Re: Public Exhibition of State Significant Development (SSD10224) – New Primary School at Edmondson Park

Attachment A – Detailed Comments

1 NORTH - EAST ELEVATION (BUCHAN AVENUE)
2000 1 : 250

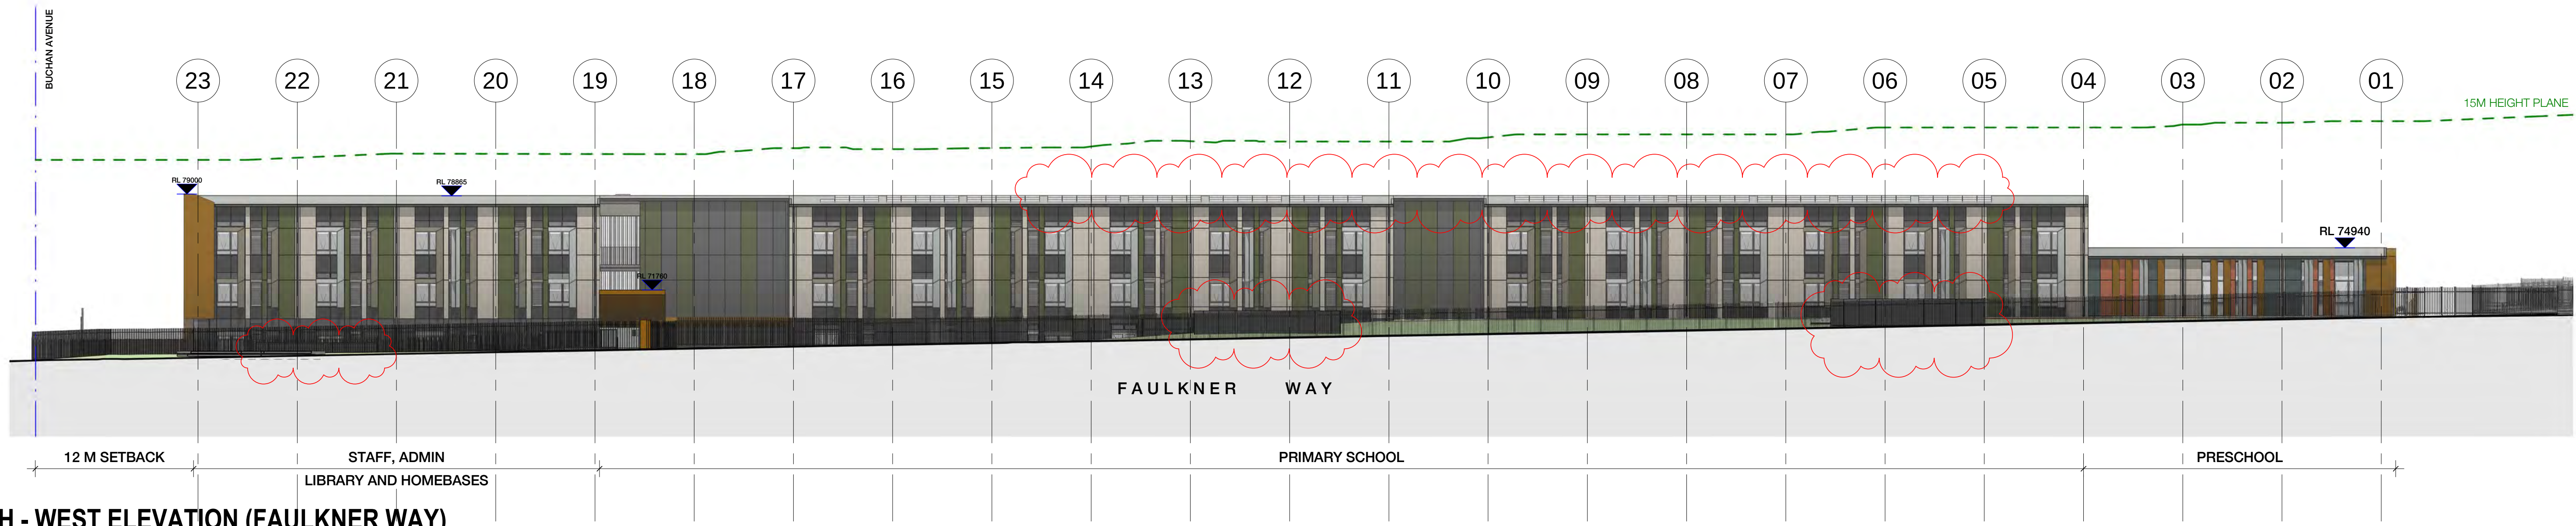
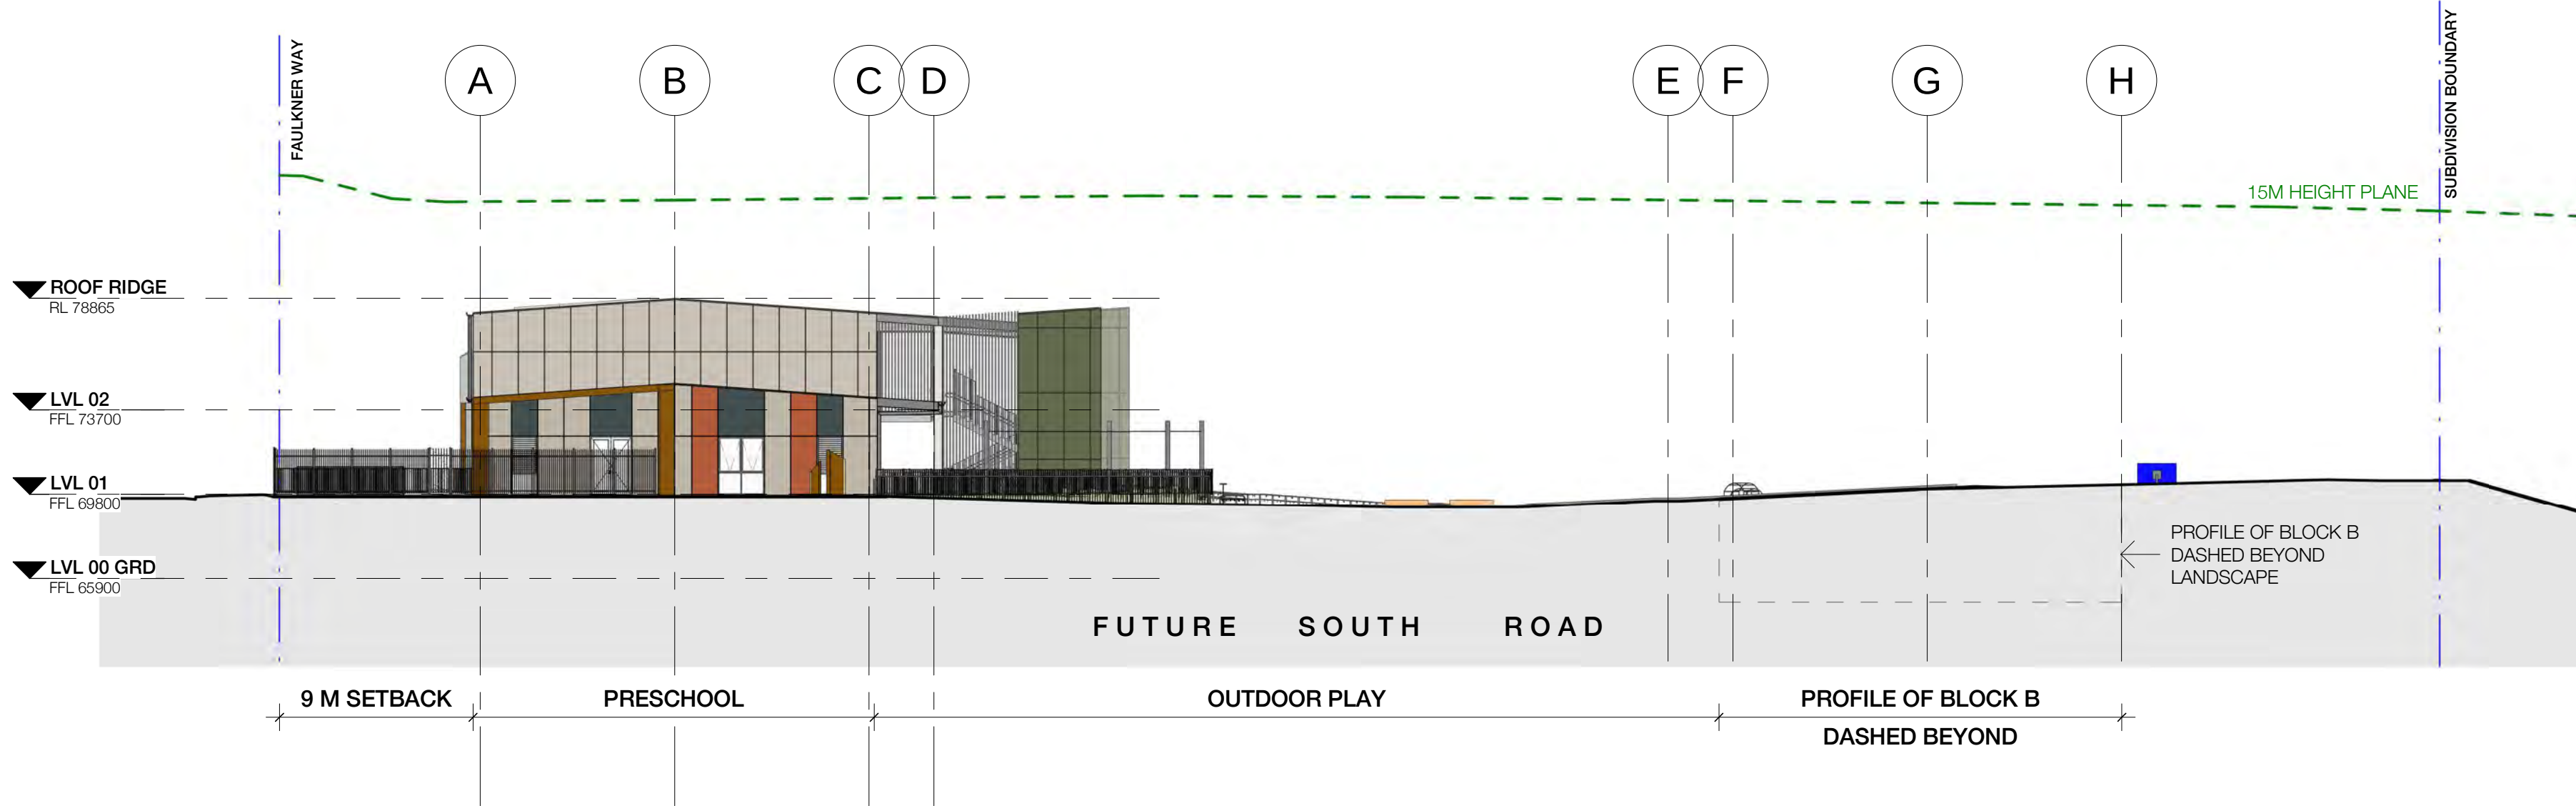
Council staff support the proposed solar panels on the roof of the Hall & COLA building. However, the Hall and COLA building appears to have a skillion roof with a south easterly aspect, which is not conducive to efficient solar power production.

- The proposal should consider locating solar panels on all buildings with a north facing roof, to optimise the efficiency of the solar panels.
- Council staff are generally supportive of the comprehensive landscape scheme submitted. However, the following suggestions should be taken into consideration, to enhance the overall success of the proposal:
